EL PASO COUNTY PLANNING AND COMMUNITY DEVELOPMENT DEPARTMENT

GRADING AND EROSION CONTROL PLAN CHECKLIST

Revised: July 2019

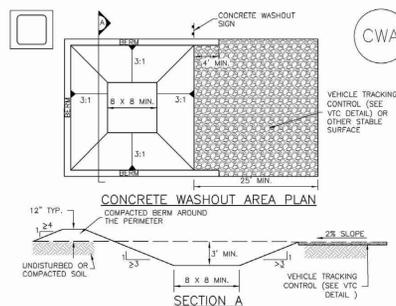
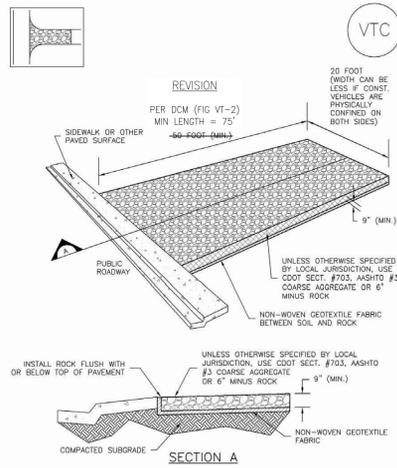
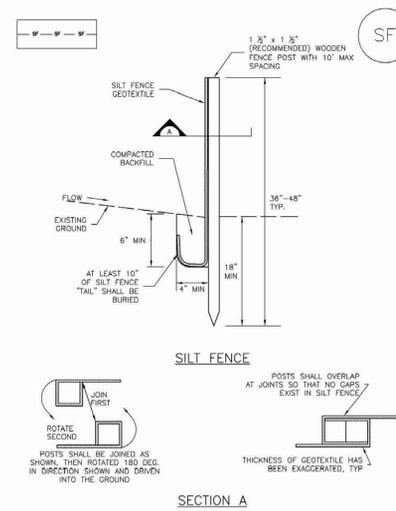
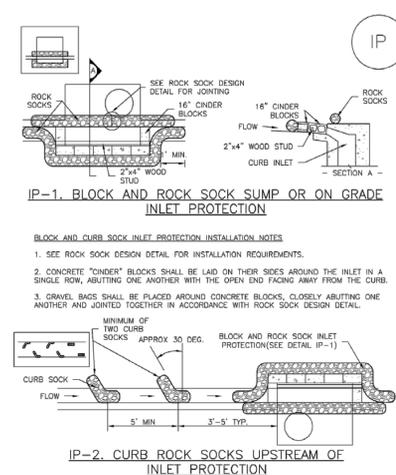
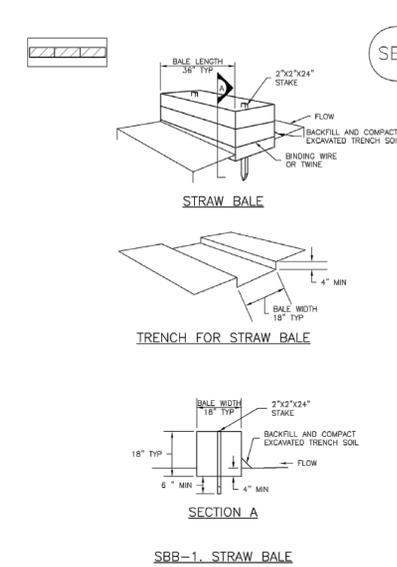
| | | Applicant | PCD |
|--|---|-----------|-----|
| z | All proposed temporary construction control measure details. Custom or other jurisdiction's details used must meet or exceed EPC standards. Details have been and or updated | X | X |
